# CITY OF PORTLAND BUILDING PERMIT

Located At 26 HAWTHORNE ST

Job ID: 2012-05-3895-SF

has permission to build a 30 by 34 foot Two Family Residence.

ROOF FRAMING PLAN

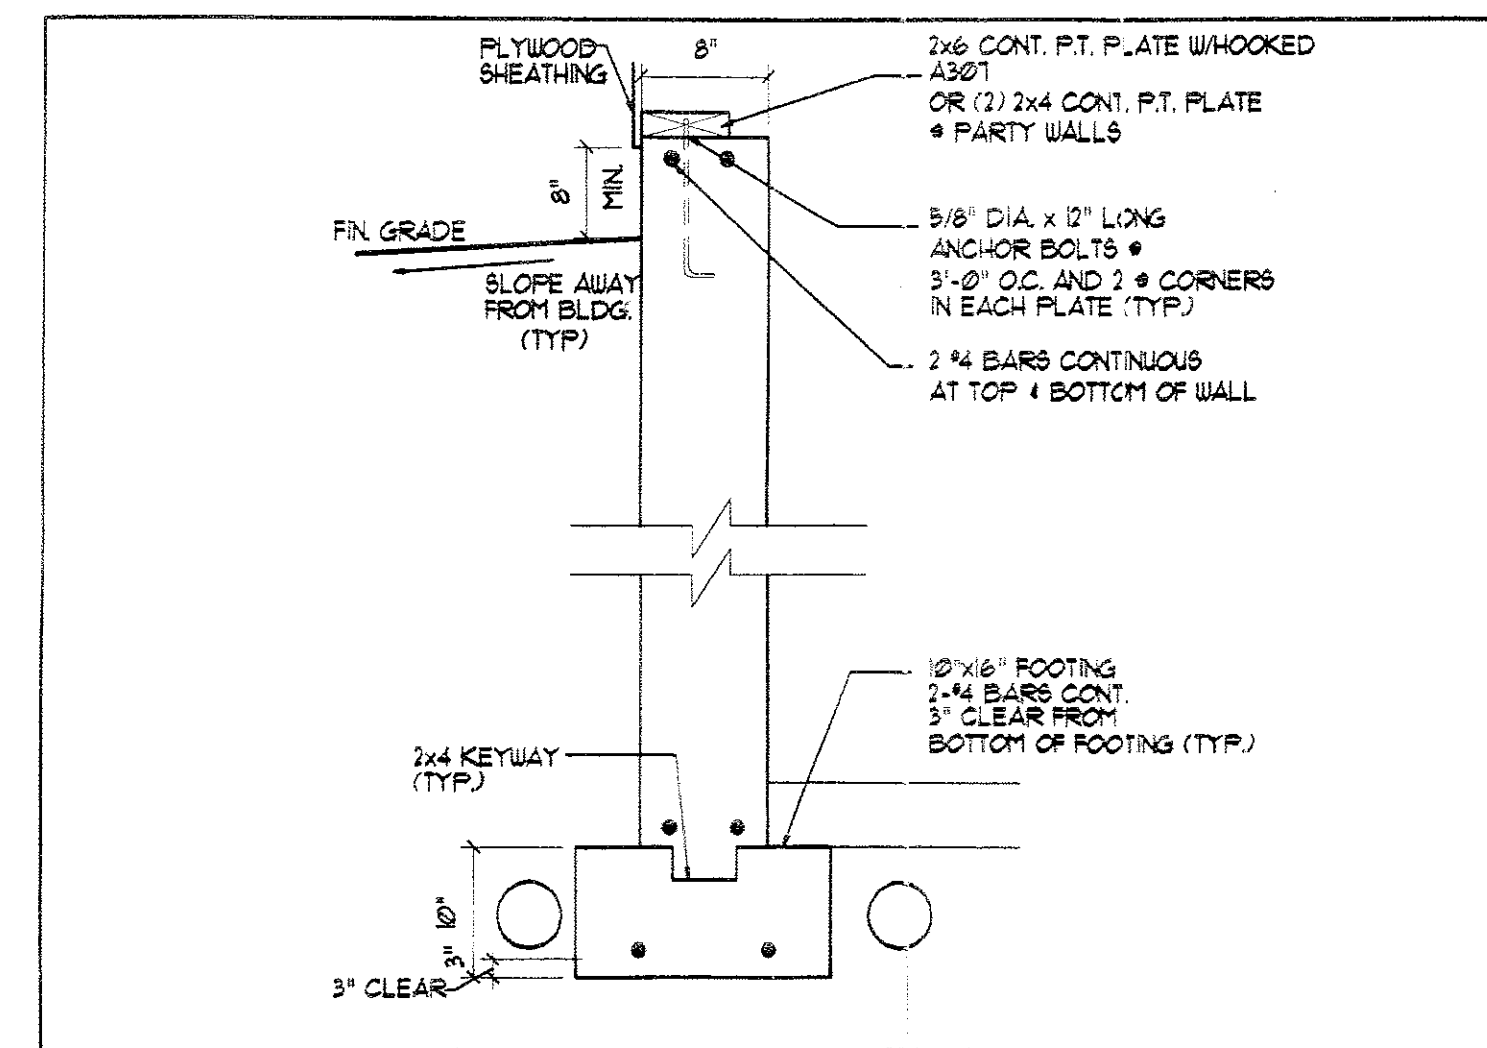
| ONE AND TWO FAMILY   | PLAN REVIEW  | CHECKLIST                            |
|--|--|--------------------------------------|
| Attic or additional Floor Joist Species<br>Dimensions and Spacing (Table R802.4(1) and<br>R802.4(2))         | Tusses   | ② Specs needed                       |

| Pitch, Span, Spacing & Dimension (Table R802.5.1(1) - R 802.5.1(8))<br>Roof Rafter; Framing & Connections (Section R802.3 & R802.3.1)                          | Trusses 24" o.c.<br>7/12 E 4/12       | (2)  |

5. Prior to construction submit specifications for Engineered Trusses and Beams.
6. R302.4 Dwelling unit rated penetrations. Penetrations of wall or floor/ceiling assemblies required to be fire-resistance rated in accordance with Section R302.2 or R302.3 shall be protected in accordance with this section.

FOUNDATION / FIRST FLOOR FRAMING PLAN

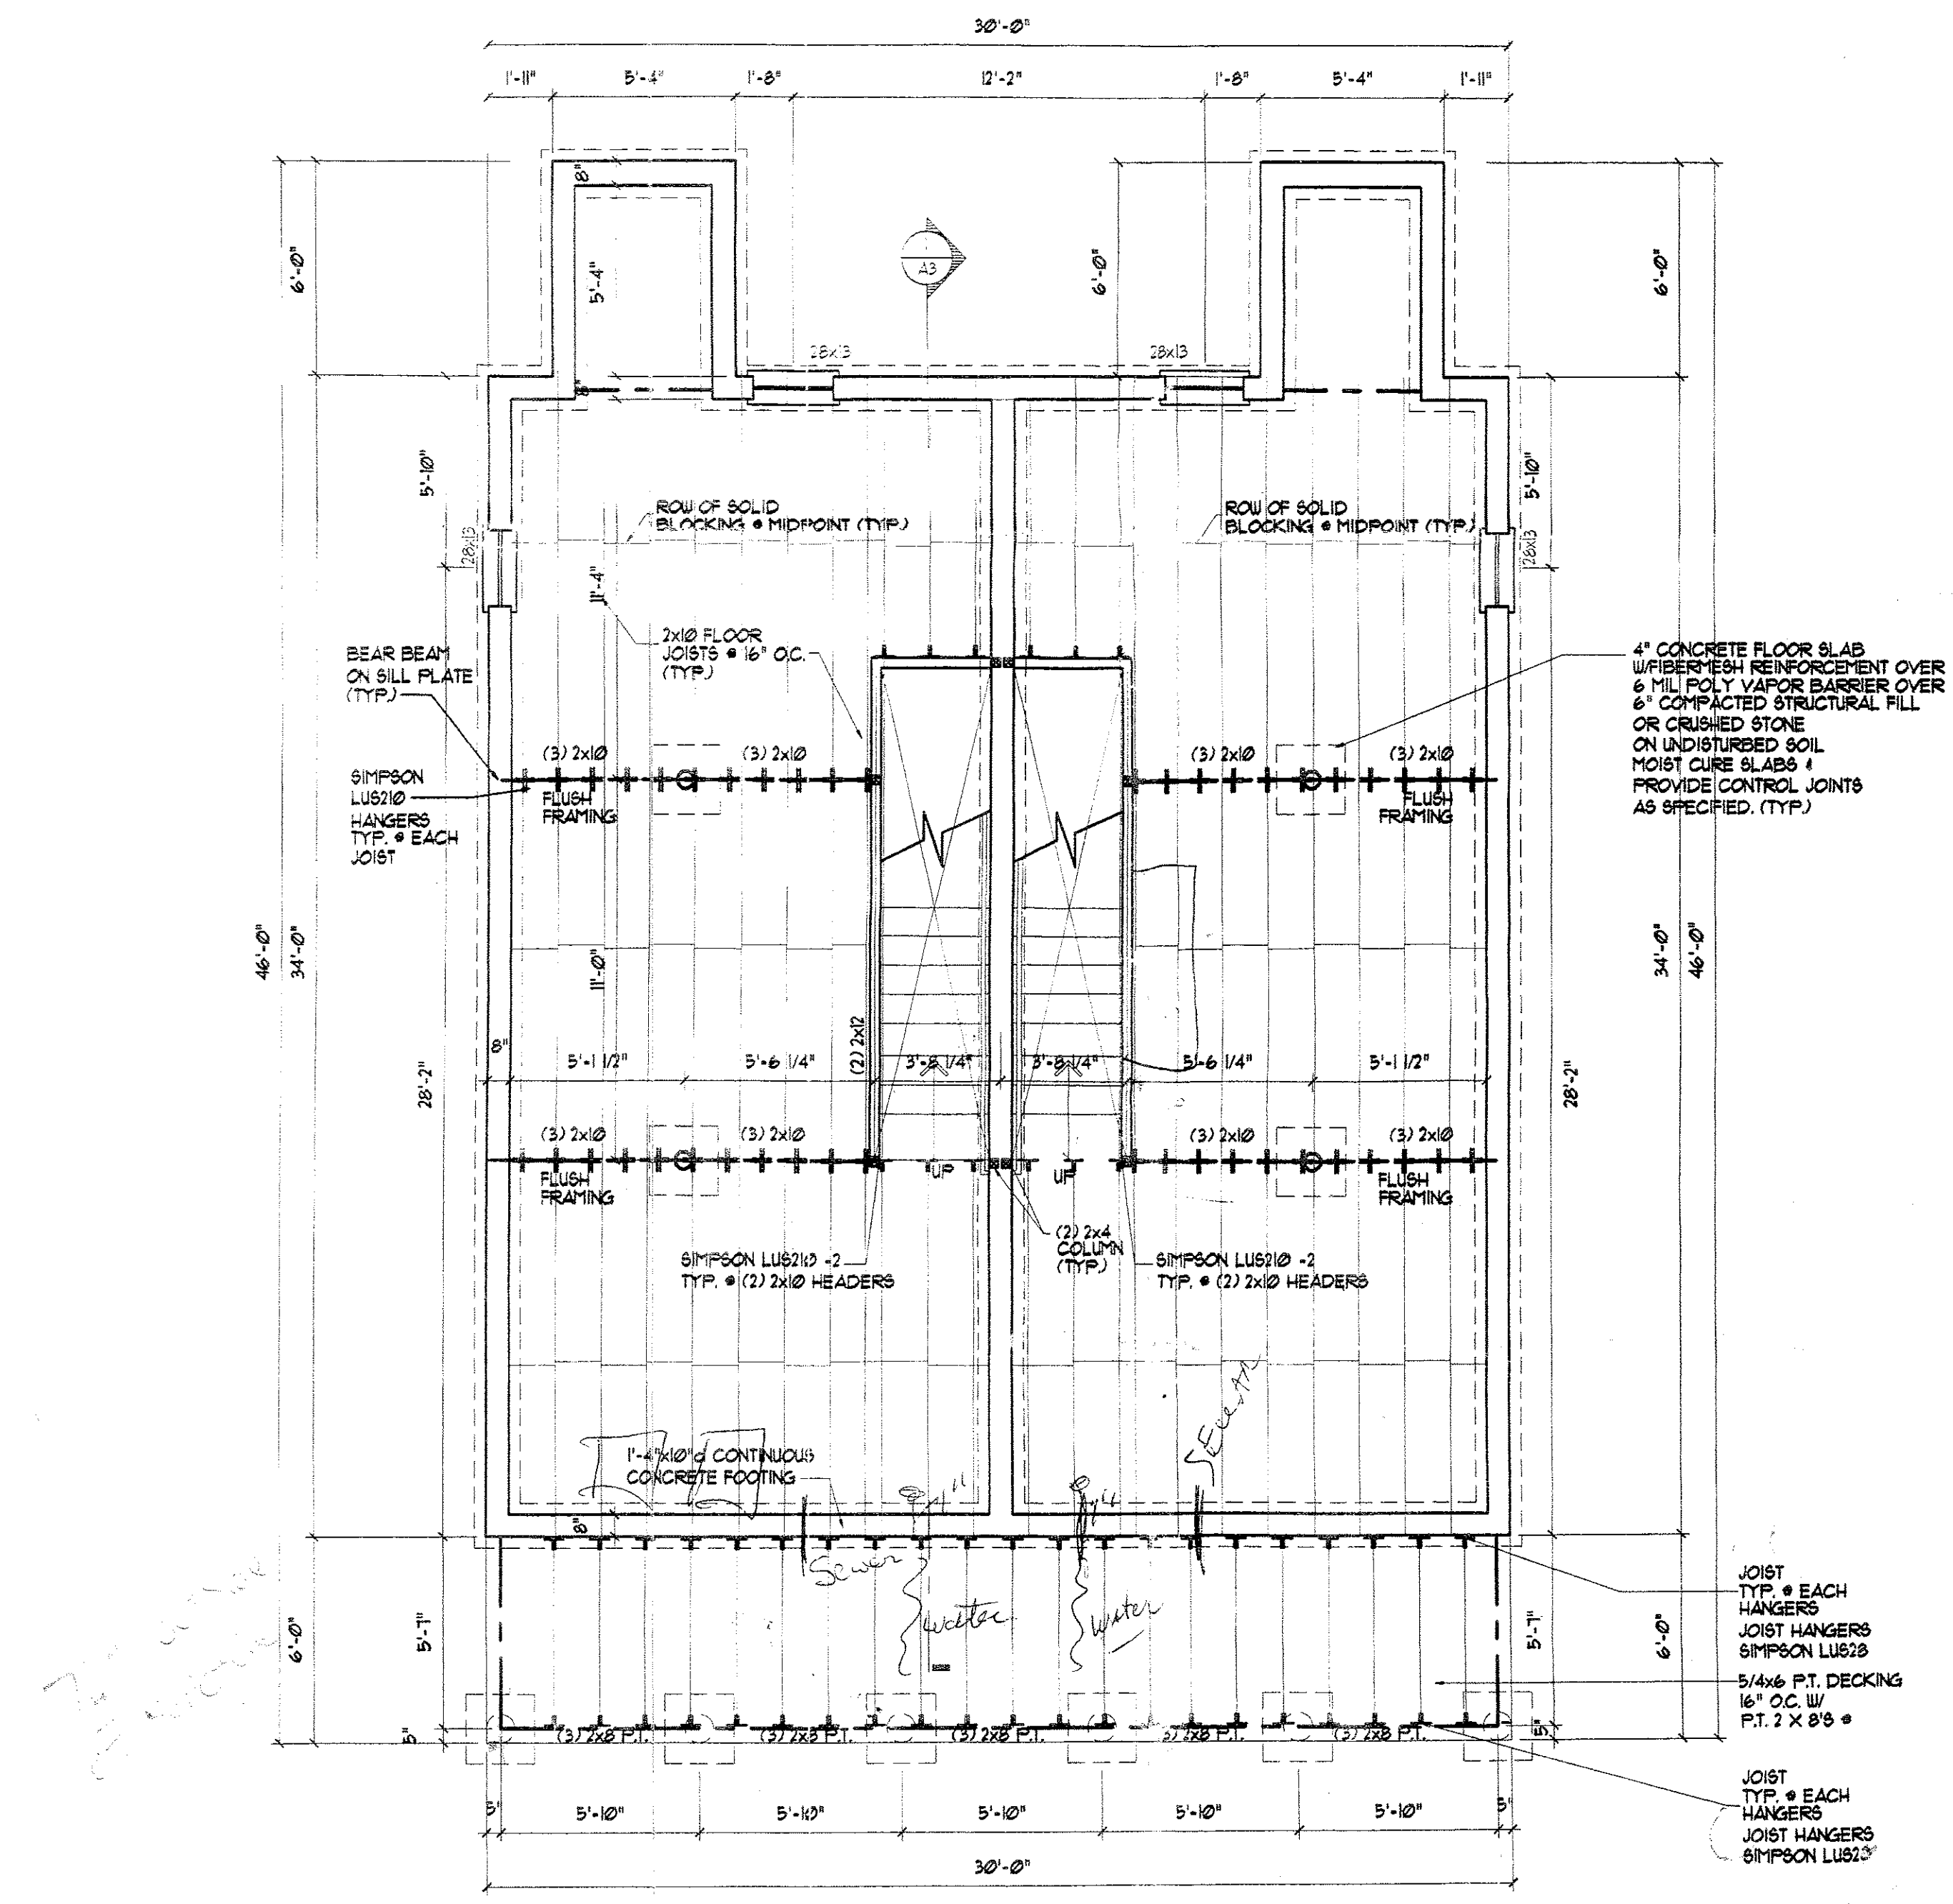
| ONE AND TWO FAMILY   | PLAN REVIEW  | CHECKLIST                            |
|--|--|--------------------------------------|
| Lally Column Type (Section R407)   | ?  | ① 3 1/2 DIA Steel                    |
| Built-Up Wood Center Girder<br>Dimension/Type  | 5 1/4" x 11 1/2" LVL's   | ② Specs needed                       |
| First Floor Joist Species<br>Dimensions and Spacing<br>(Table R502.3.1(1) & Table R502.3.1(2) )              | 2x12" @ 12" O.C.<br>Floor (entire) covered?                      | ⑥ 12" overhang                       |

11. R407.3 Structural requirements. The columns shall be restrained to prevent lateral displacement at the bottom end. Wood columns shall not be less in nominal size than 4 inches by 4 inches. Steel columns shall not be less than 3-inch-diameter Schedule 40 pipe manufactured in accordance with ASTM A 53 Grade B or approved equivalent.

14. R502.3.3 Floor cantilevers. Floor cantilever spans shall not exceed the nominal depth of the wood floor joist. Floor cantilevers constructed in accordance with Table R502.3.3(1) shall be permitted when supporting a light-frame bearing wall and roof only.

SECTION THRU HOUSE
 SCALE: 1/4" = 1' - 0"

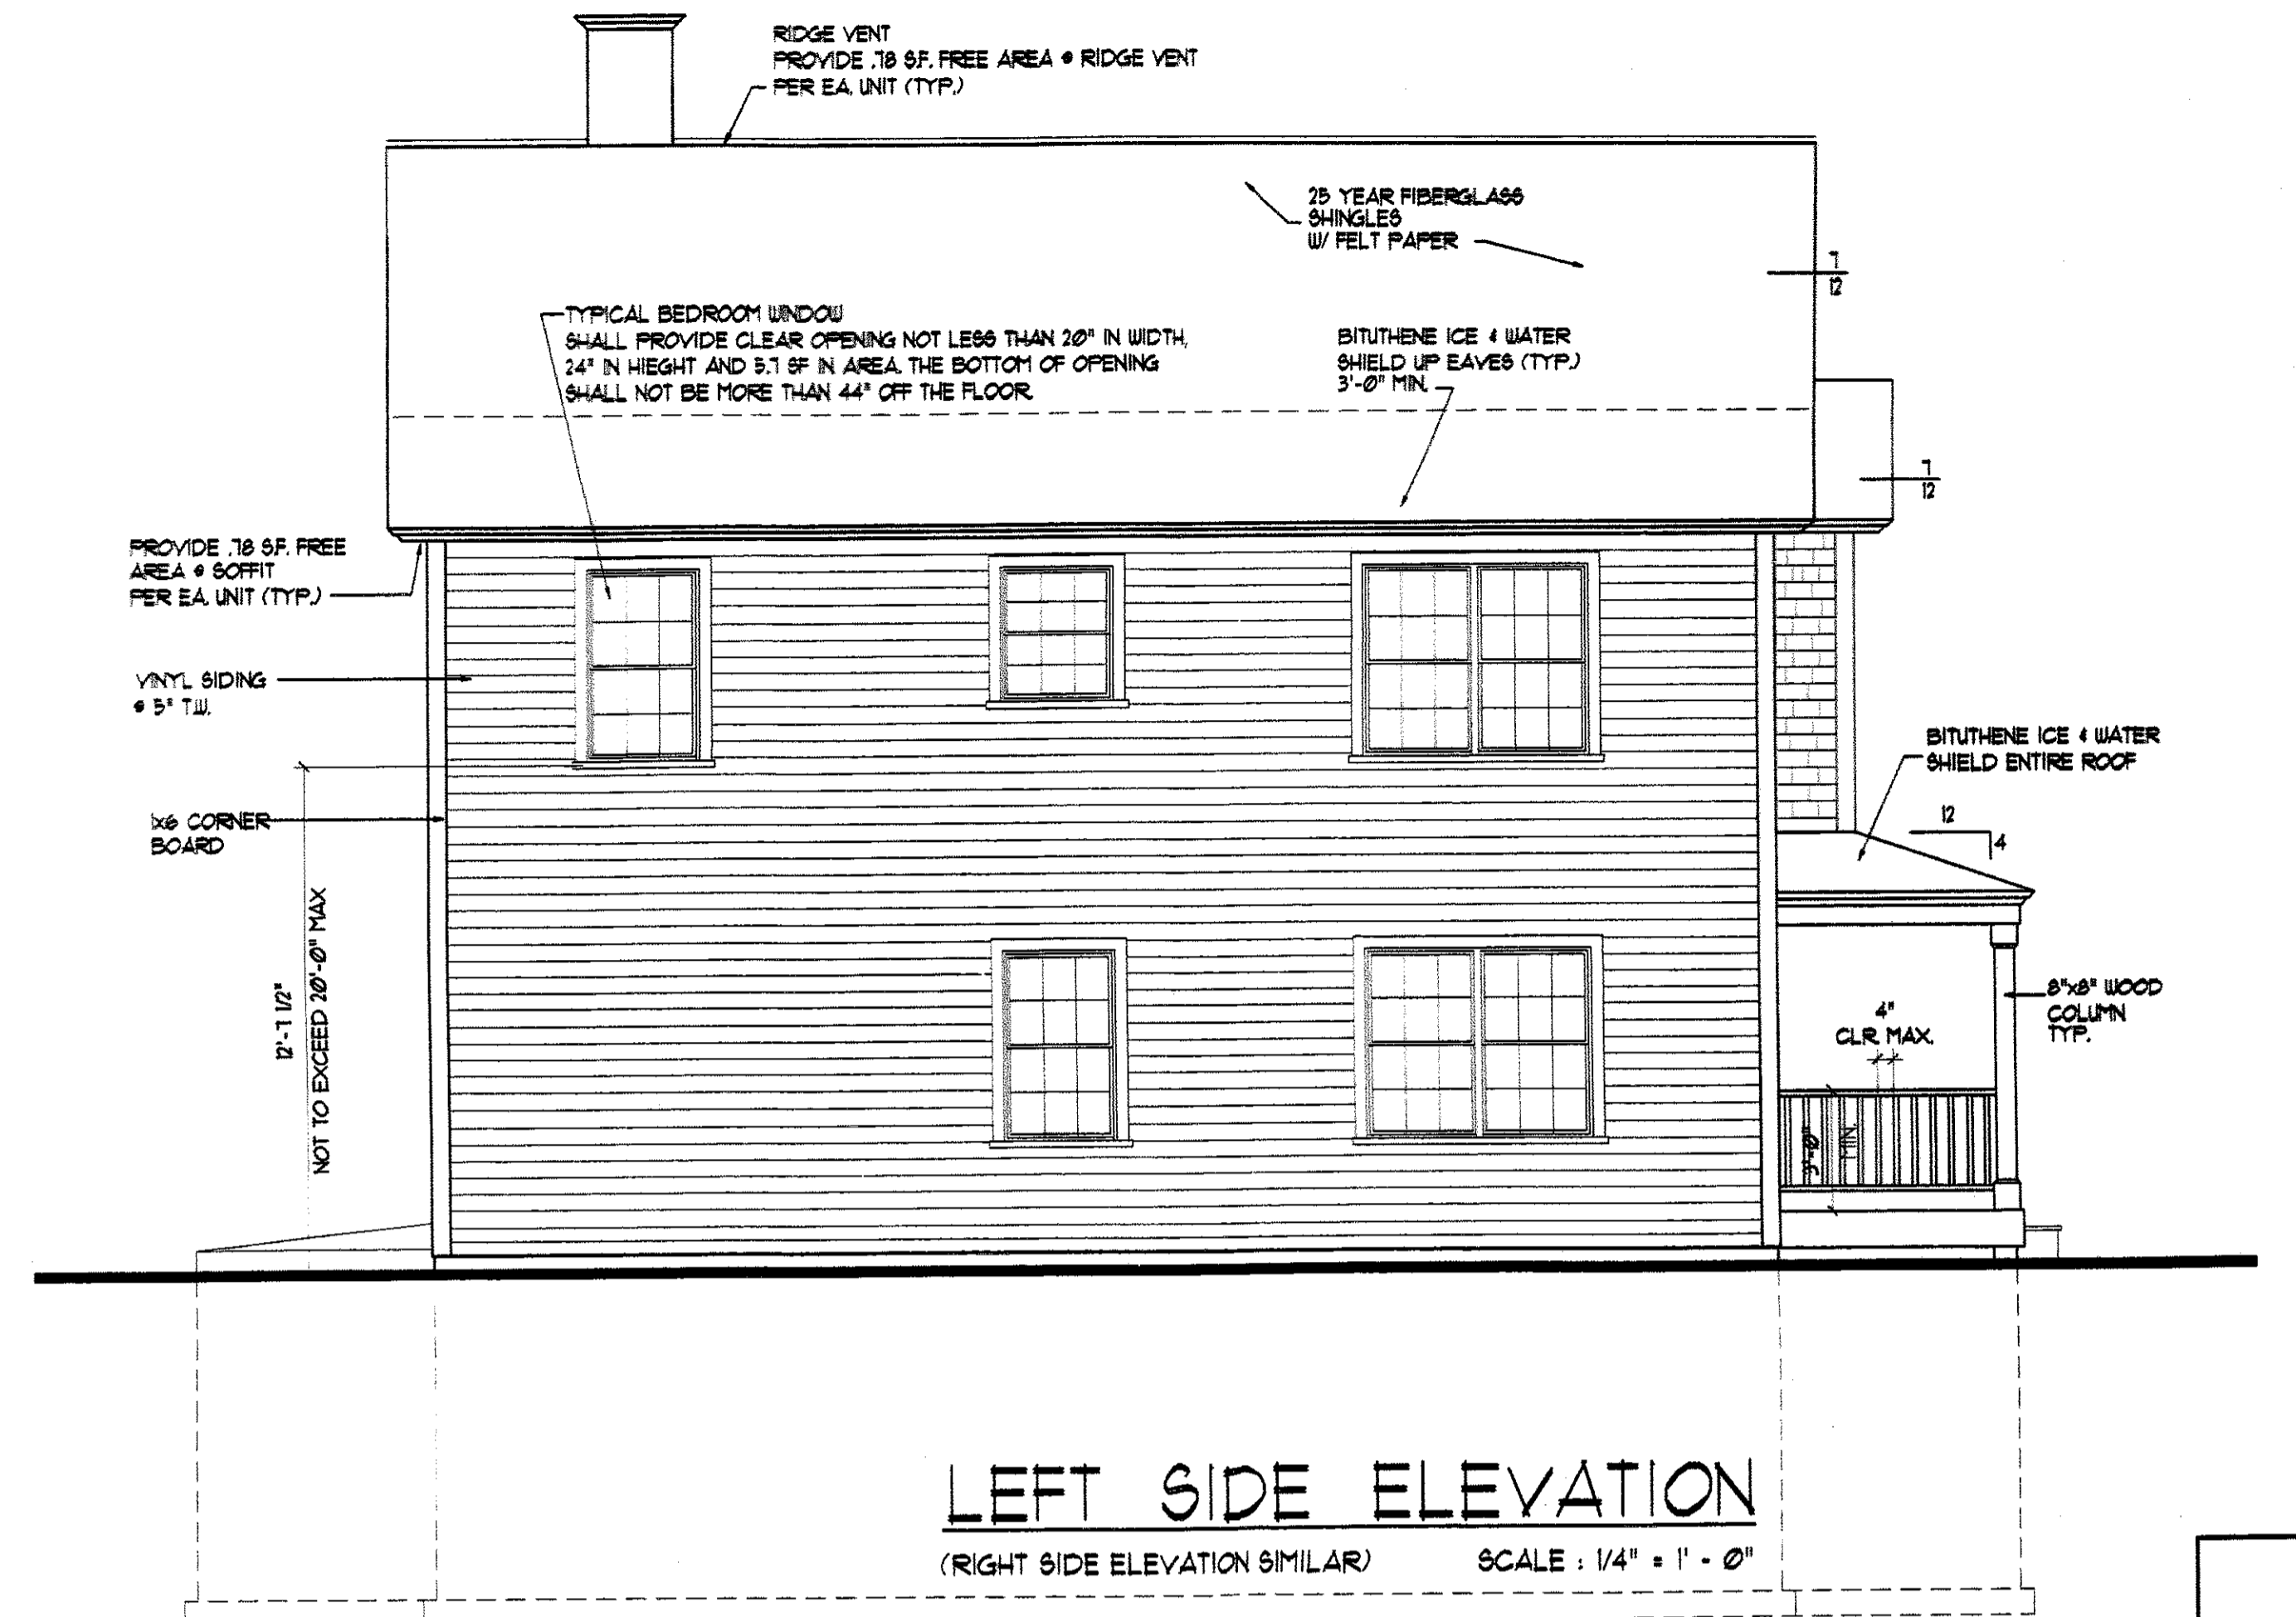
| Attic Access (Section R807)  | "Scuttle" shown                       | 22x30" Req. (4)  |

12. R807.1 Attic access. Buildings with combustible ceiling or roof construction shall have an attic access opening to attic areas that exceed 30 square feet and have a vertical height of 30 inches or greater. The vertical height shall be measured from the top of the ceiling framing members to the underside of the roof framing members. The rough-framed opening shall not be less than 22 inches by 30 inches and shall be located in a hallway or other readily accessible location.
